Subject: 38 Arundel Road Littlehampton BN17 7DB - LU/327/20/PL

Planning Application reference: LU/327/20/PL

Proposal: Application under Regulation 3 of the Town and Country Planning (General Regulations) 2015 for the change of use of single dwellinghouse to 2 No. residential apartments & associated external alterations. This site is in CIL Zone 4 (Zero Rated) as flats.

DRAWING TITLE
 PROPOSED FLOOR PLANS

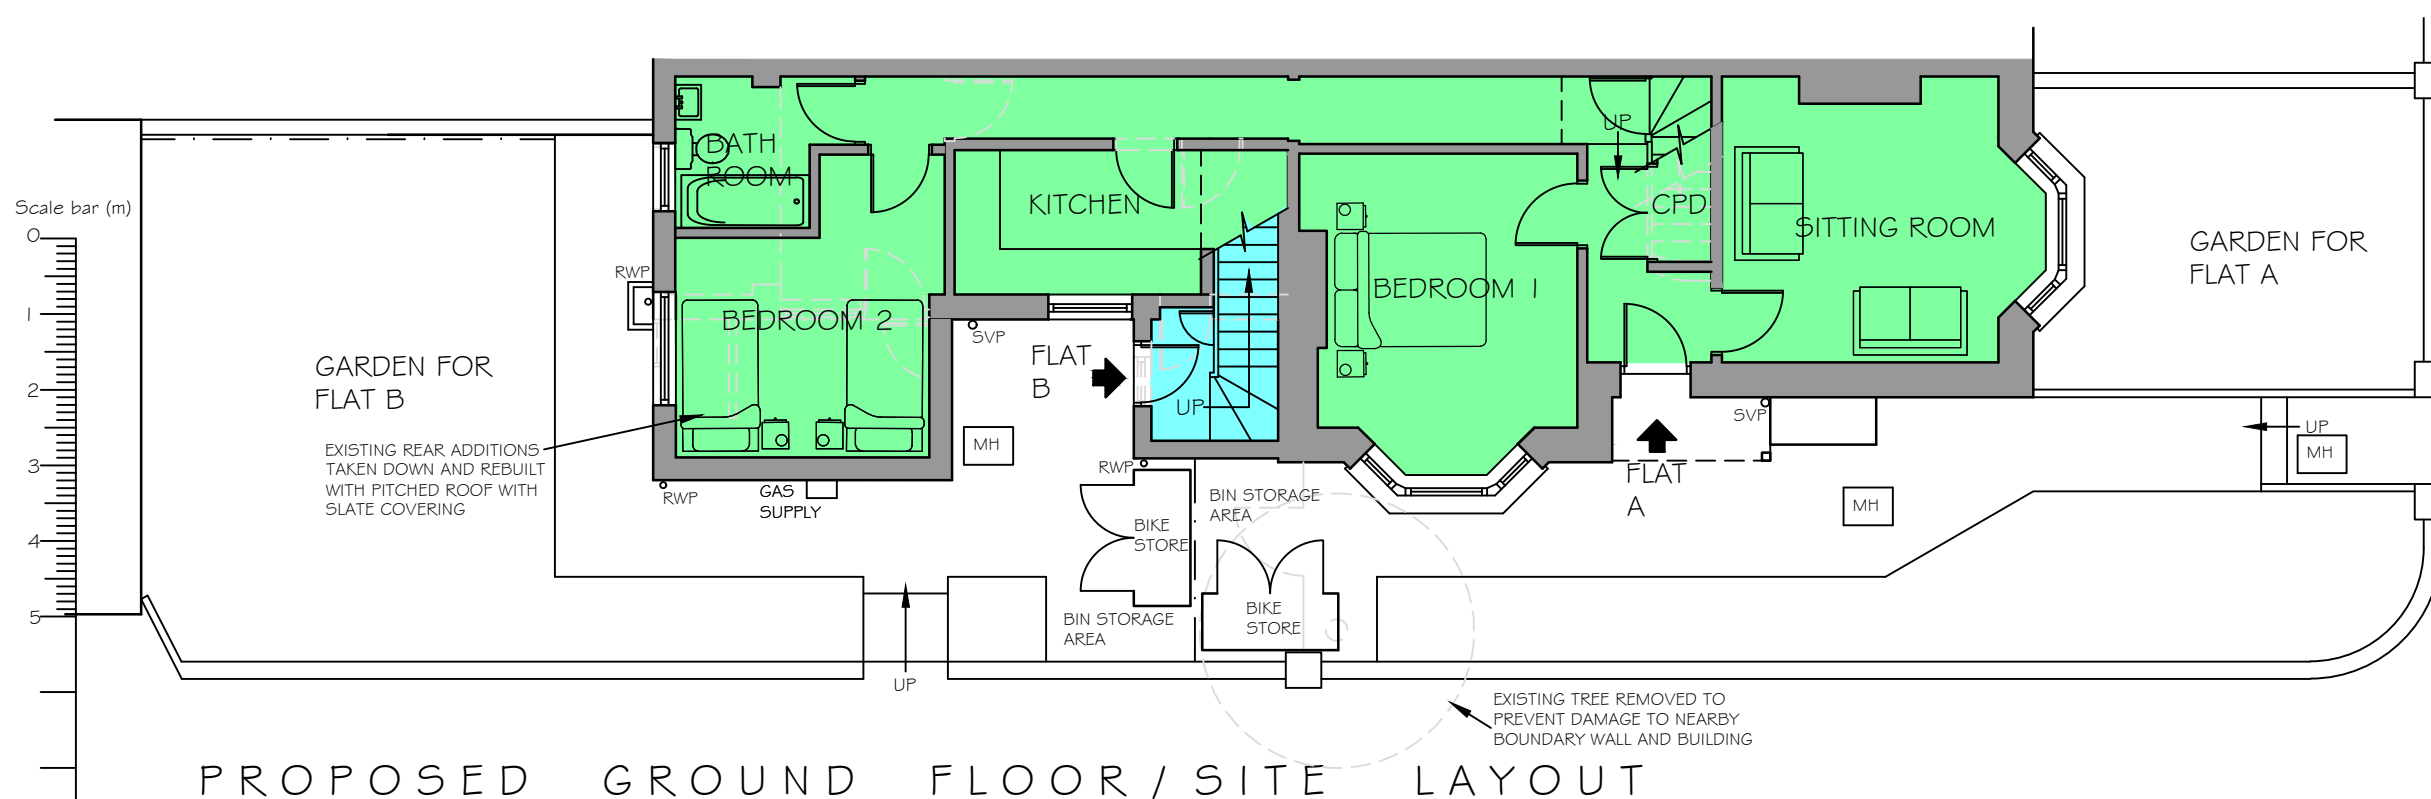
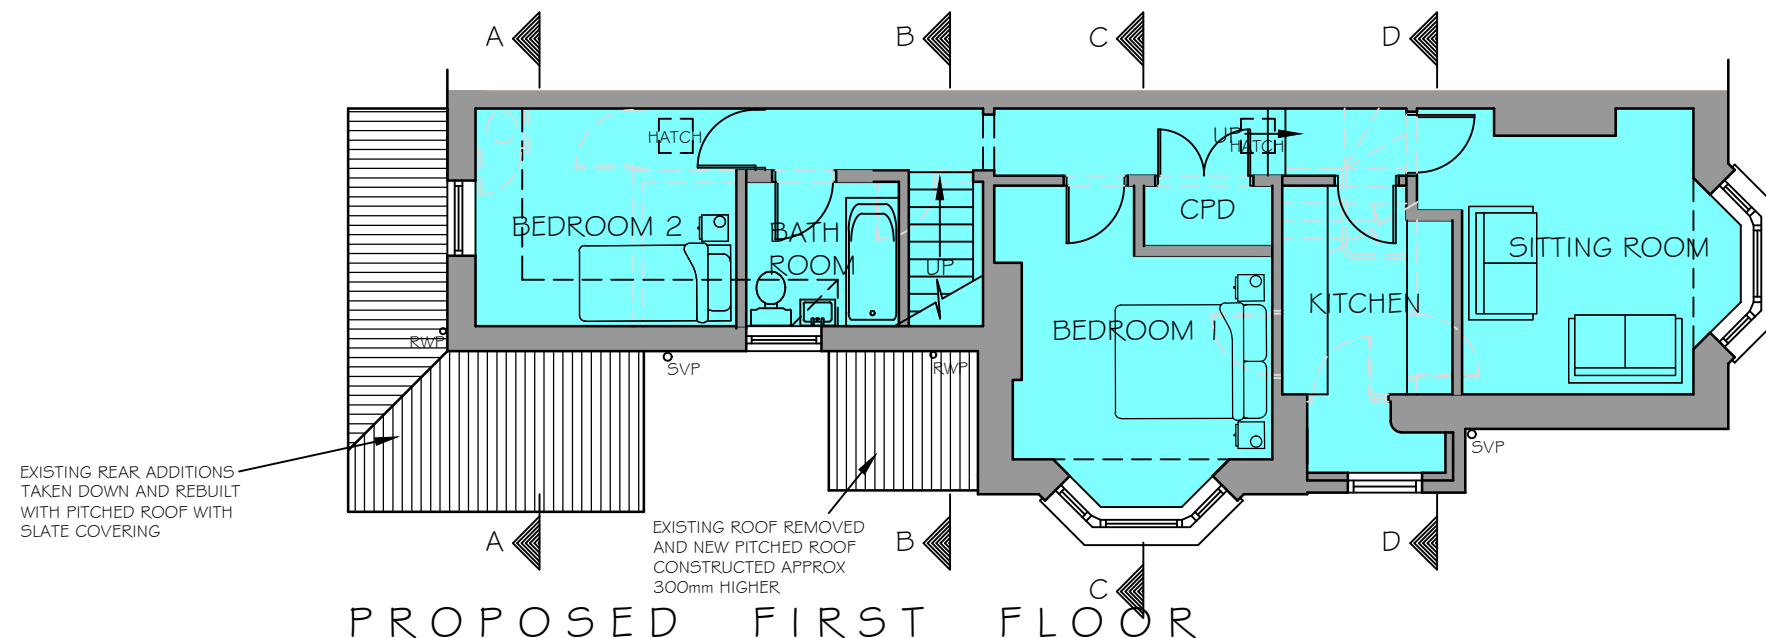
As the use of laminated flooring could contribute to structure-borne noise transmission causing a detrimental impact to the amenities of vertically adjacent residents, the installation of a hard floor finish such as laminate or hardwood overlay, ceramic tiles or bare floorboards in any room in the proposed development [excluding rooms on the ground floor], is prohibited. The use of carpets, carpet tiles, foam backed linoleum and any other soft floor finish is acceptable.

A hard floor finish is acceptable in bathrooms on the first floor. Where a hard floor finish is proposed, and the first floor bathroom is vertically adjacent to habitable rooms, an approved high quality acoustic underlay must also be installed
